From: Michael Eastham <Michael.Eastham@arun.gov.uk>
Sent: 13 May 2021 16:59
To: Planning.Responses <Planning.Responses@arun.gov.uk>
Subject: FW: Objection to Planning application WA/93/20/PL: Land East of Tye Lane, Walberton.

Objection to Planning application WA/93/20/PL: Land East of Tye Lane, Walberton.

Appendix B
Traffic Flow Diagrams

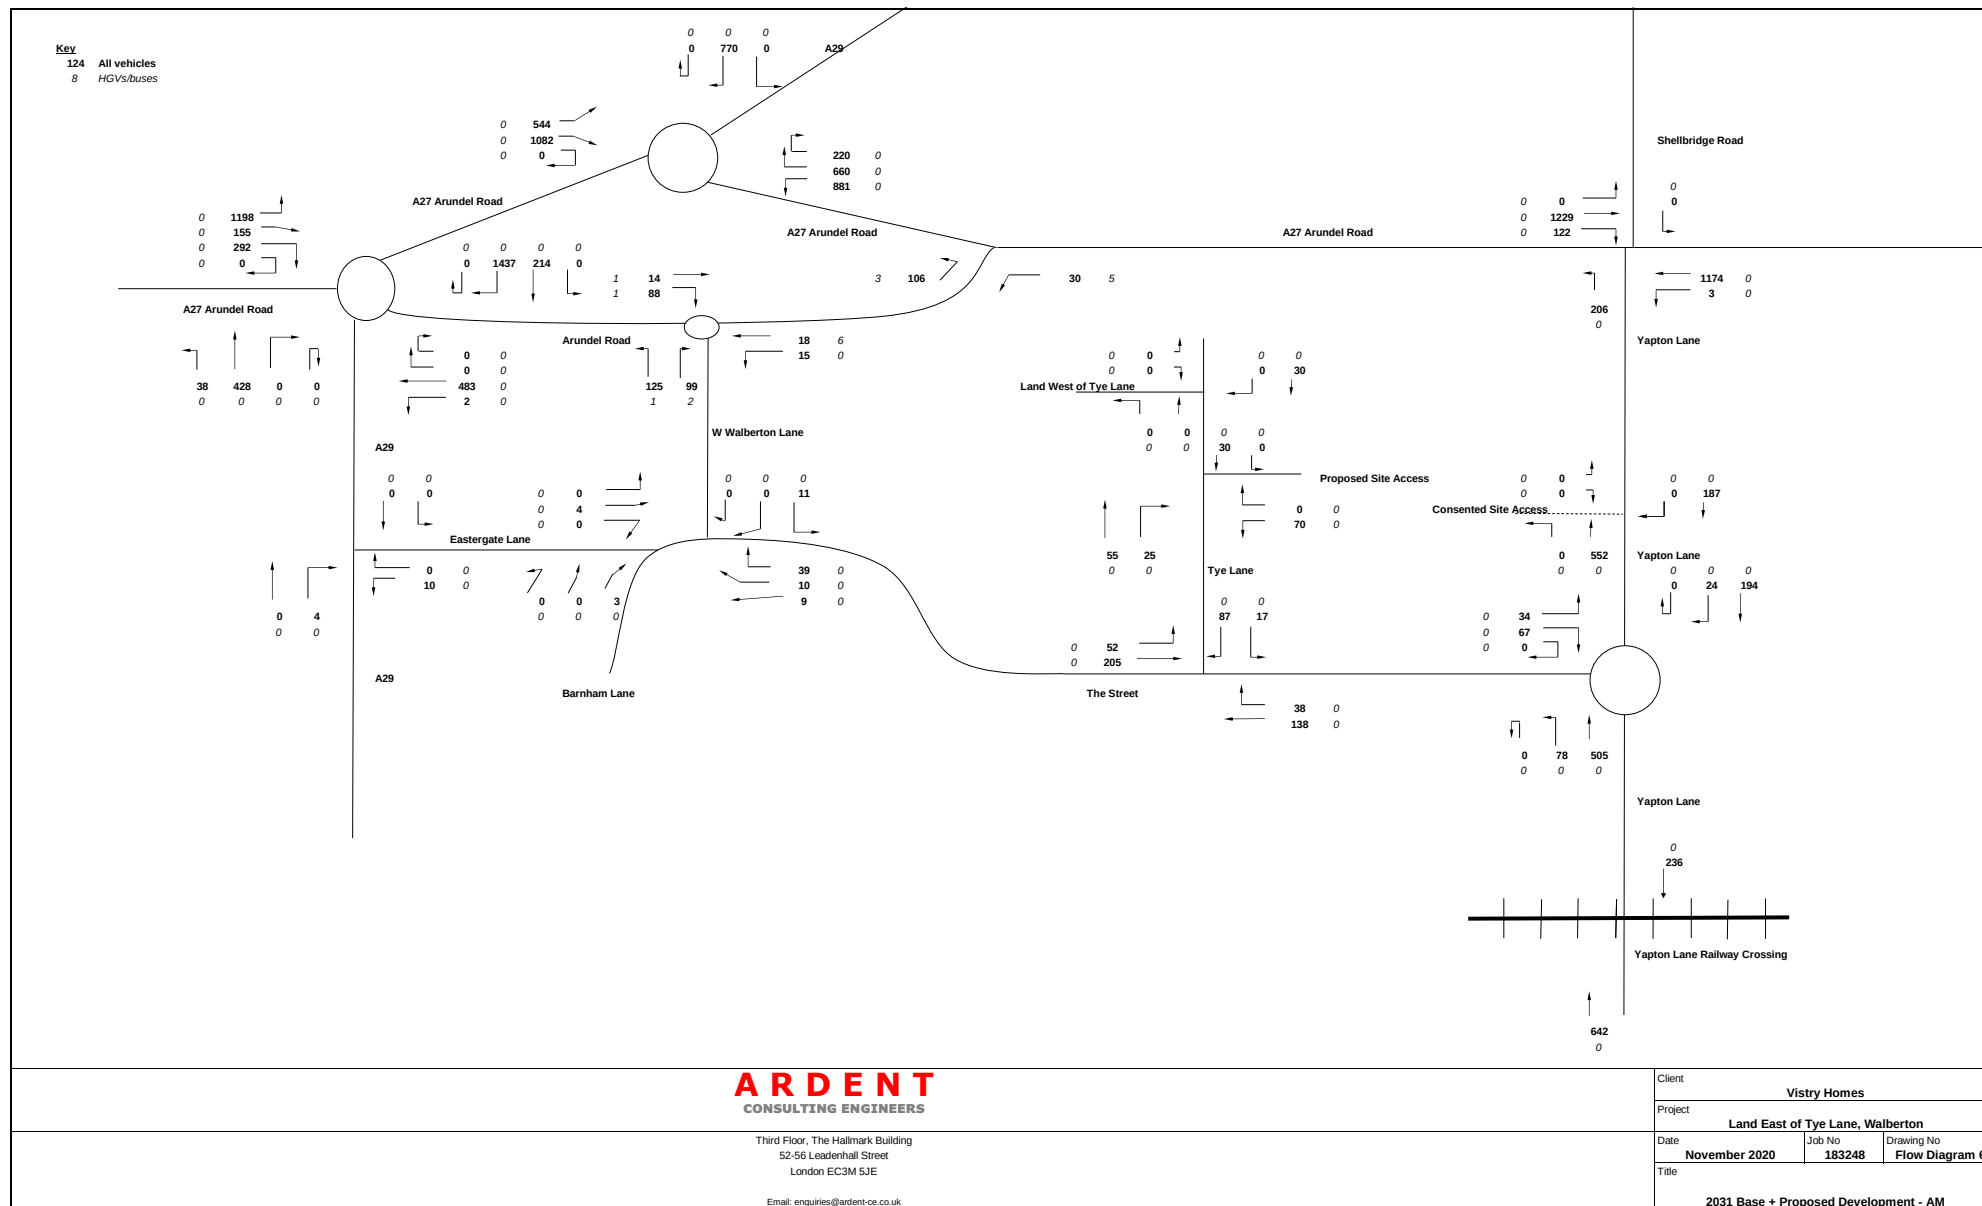
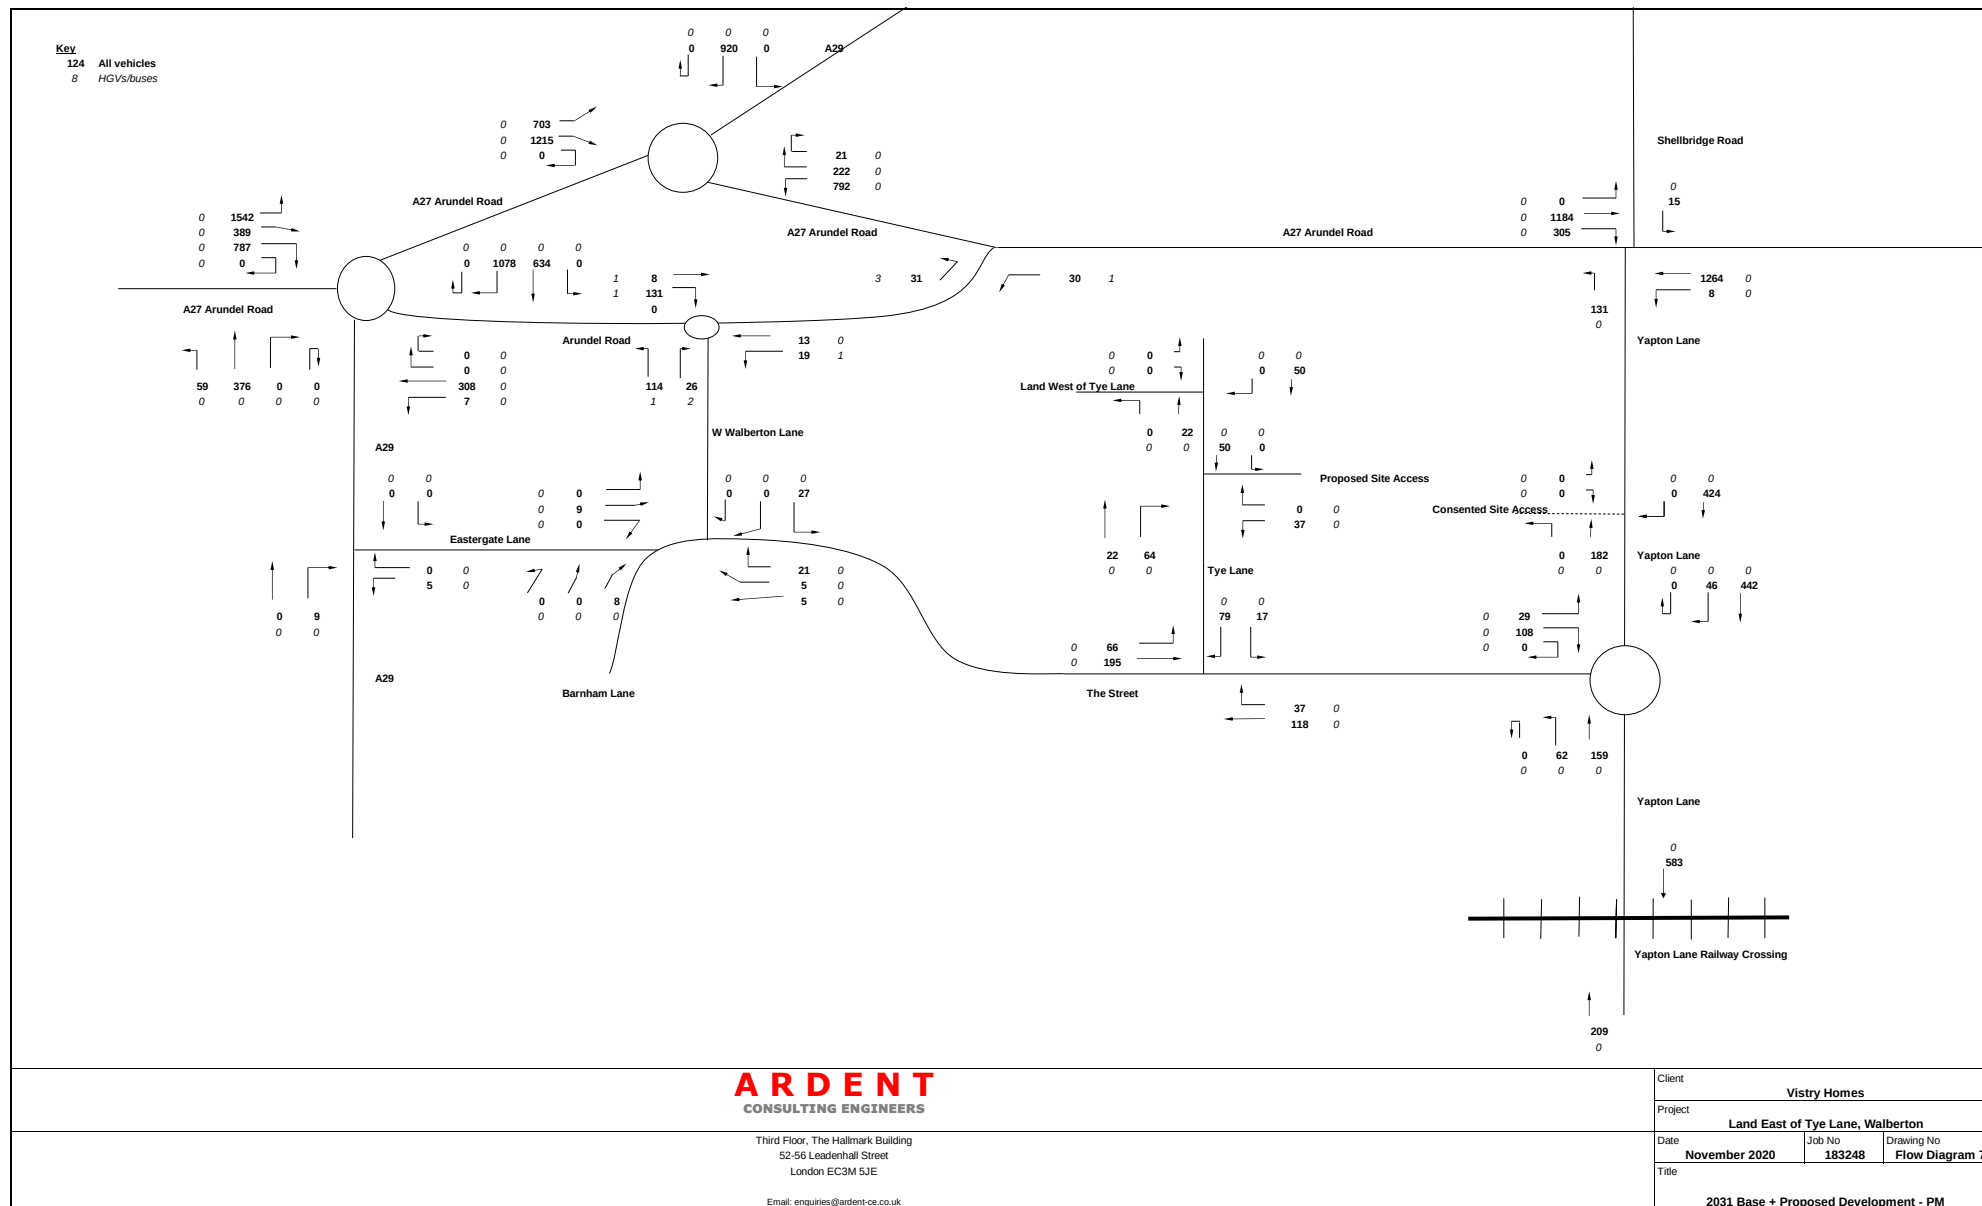
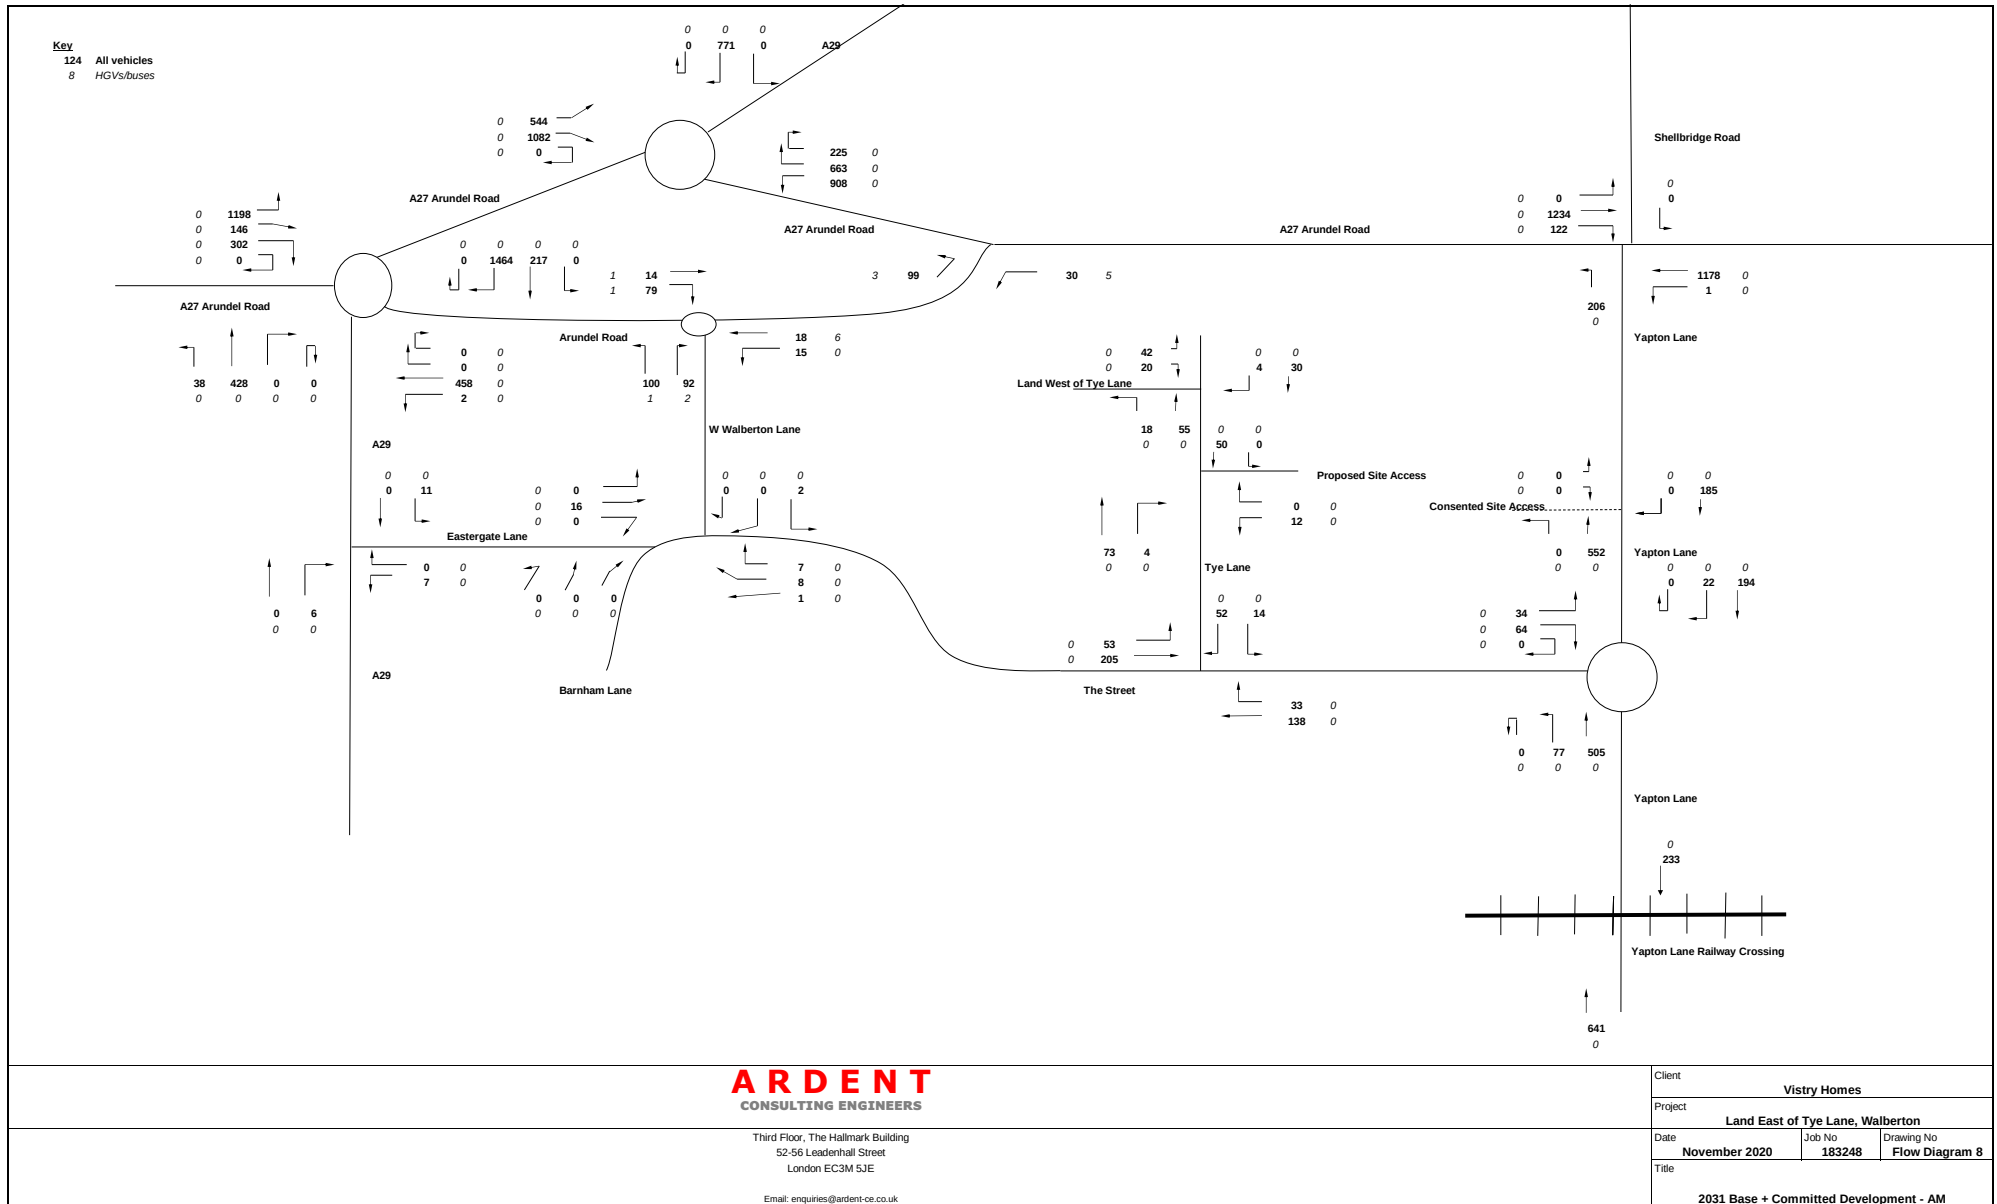
- A number of Traffic Flow Diagrams that are provided seem to have incorrect data. The 2031 base numbers used refer to 50 vehicles going northwards up Tye Lane to a dead end and 30 heading southbound from this dead end. Also, there would appear to be very few vehicle users predicted for 175 (soon to be 205) dwellings. The conclusion is that more traffic than described in the flow diagrams will be using local roads unsuited for this level of traffic. The application should be refused until correct information can be supplied, and the local impacts assessed.
